Ribble Valley Borough Council
Housing & Development Control

Your ref: 3/2022/1180
Our ref: D3.2022.1180
Date: 13th February 2023

Application no: **3/2022/1180**

Address: **Pinfold Farm Preston Road Ribchester PR3 3YD**

**IMPORTANT NOTES**

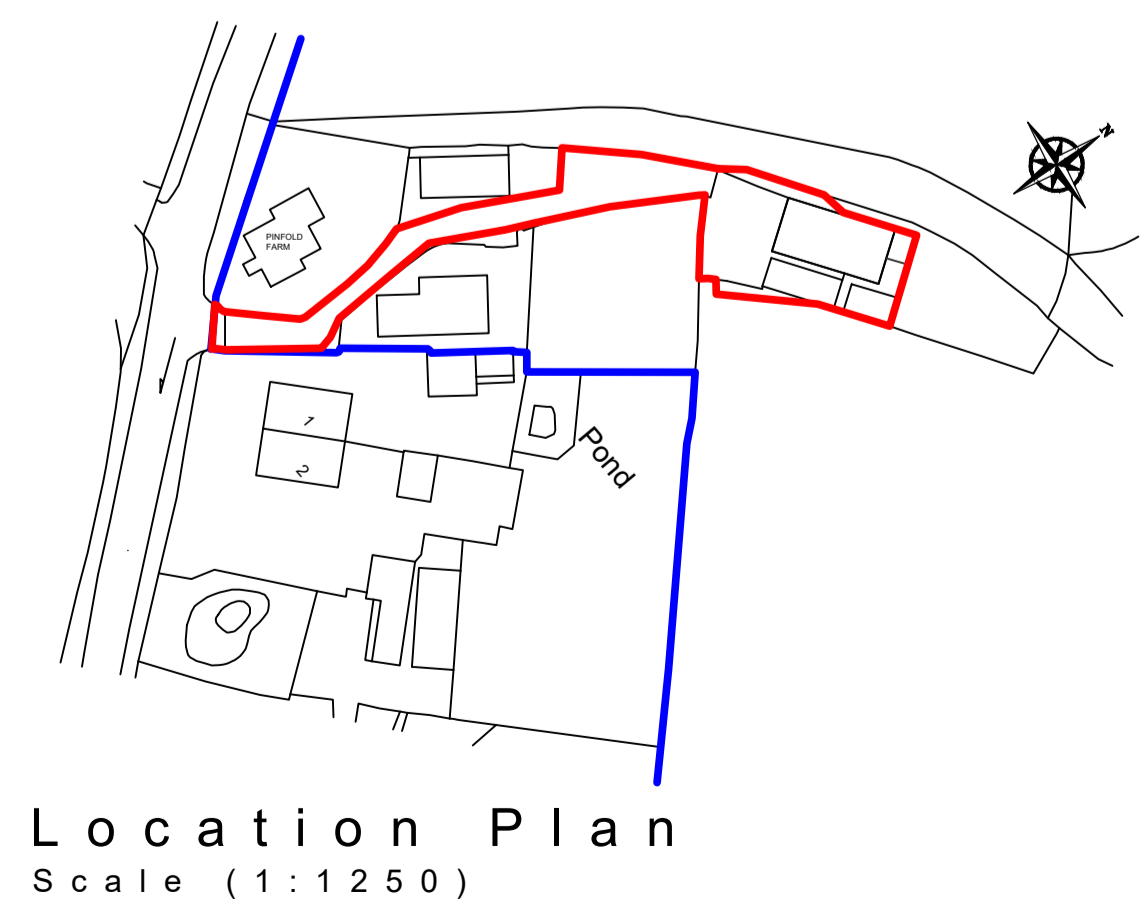
The LHA have reviewed Holden drawing reference 009 titled "Site Plans" and are aware that the access to the proposal has already been approved by the LHA under application reference 3/2021/1271 and 3/2020/0855, which was for the same scheme at the site. Therefore, given the access remains unaltered and the proposal will not fully intensify the use of the access, the LHA have no objection to the proposal.

The LHA have reviewed Holden drawing reference 009 titled "Site Plans" and are satisfied that the parking arrangements comply with the LHAs parking guidance found in the Joint Lancashire Structure Plan. Therefore, the LHA have no further comments to make.

1. The development hereby permitted shall not be occupied until such time as the parking and turning facilities have been implemented in accordance with Holden drawing reference 009. Thereafter the onsite parking provision shall be so maintained in perpetuity.
